OFFICIAL NOTICE OF DECISION

CITY OF ALBUQUERQUE
PLANNING DEPARTMENT
DEVELOPMENT REVIEW BOARD

4. Project # 1003762

ISAACSON & ARFMAN PA agent(s) for CHELWOOD HILLS LLC request(s) the above action(s) for all or a portion of Tract(s) B, CHELWOOD ELEMENTARY SCHOOL (to be known as **CHELWOOD HILLS SUBDIVISION**) zoned R-LT, located on EASTRIDGE PARK BLVD NE, between CHELWOOD PARK BLVD NE and INDIAN SCHOOL RD NE containing approximately 4 acre(s). [REF: 04EPC-01714, 05DRB-00316] (J-22)

**PRELIMINARY PLAT  
FOR  
CHELWOOD HILLS  
SUBDIVISION**  
BEING A REPLAT OF  
TRACT B  
CHELWOOD ELEMENTARY SCHOOL  
SECTION 15 T. 10 N., R. 4 E., N.M.P.M.  
CITY OF ALBUQUERQUE  
BERNALILLO COUNTY, NEW MEXICO

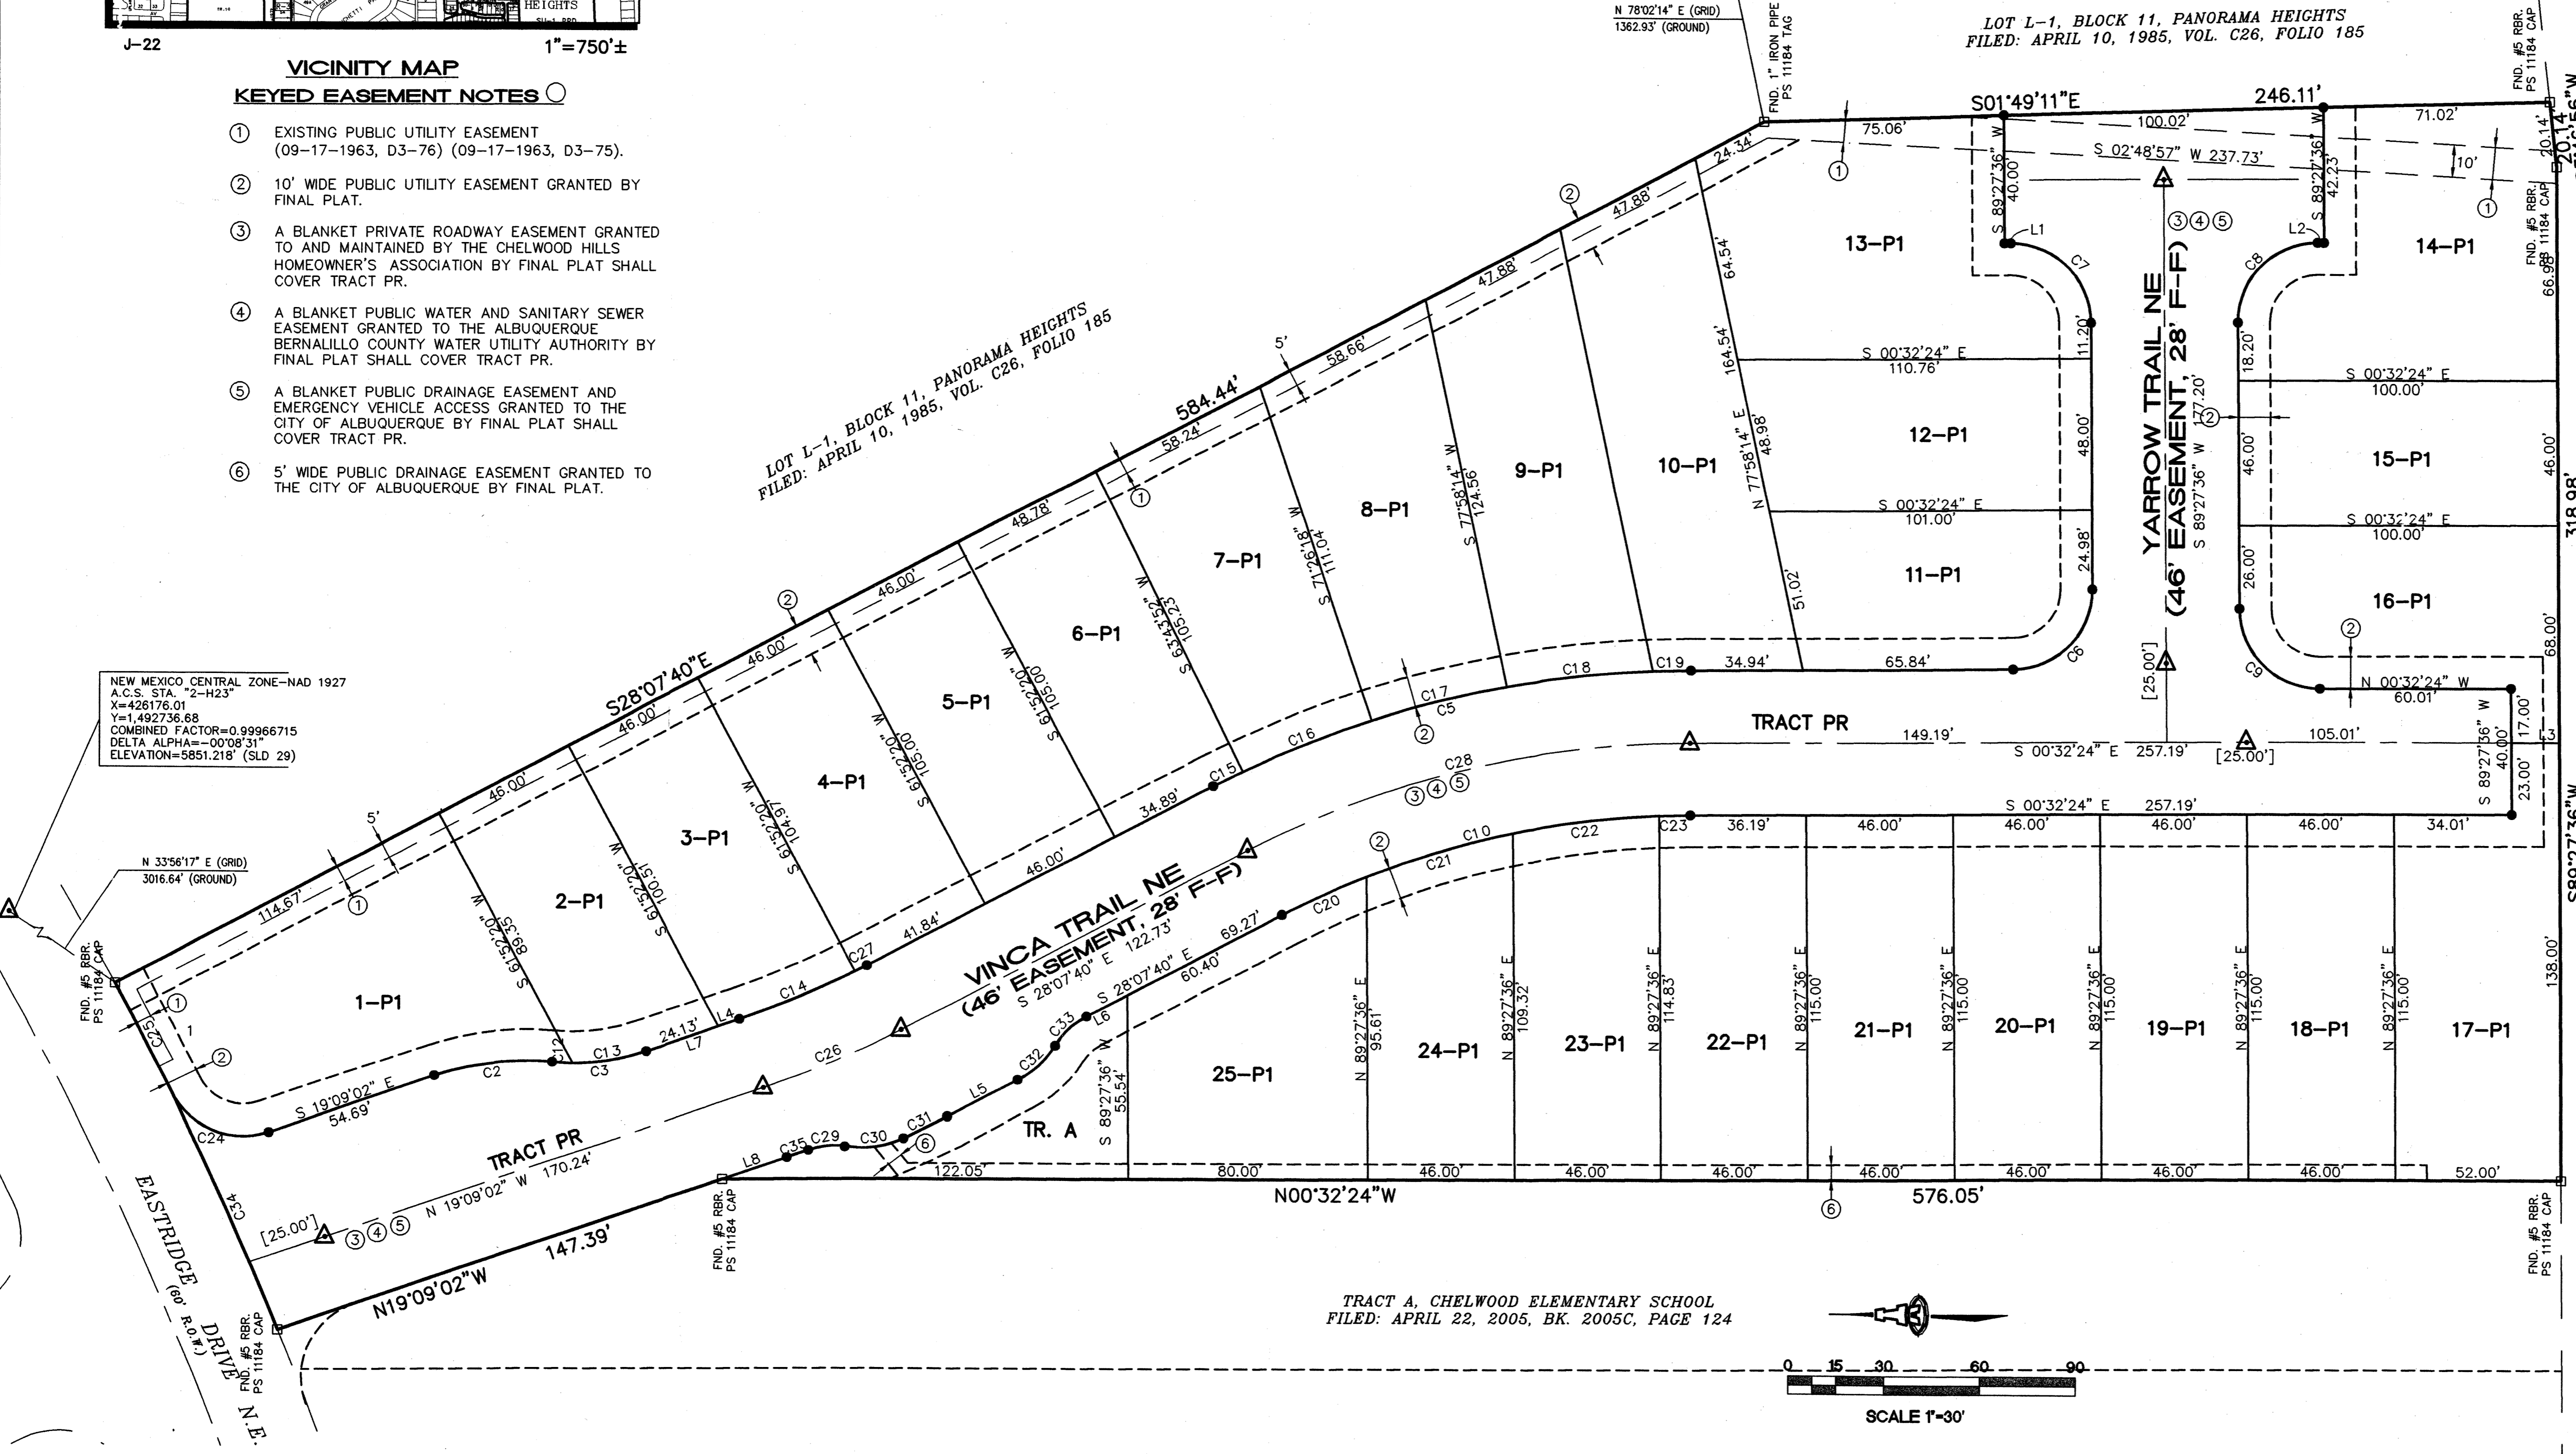
Make the drainage easement along the west side "private" and establish maintenance and beneficiaries.

The lot lines on Lots 11-P1, 12-P1 and 13-P1 will need adjustment to meet the 20-foot sideyard setback on Lot 20-P1.
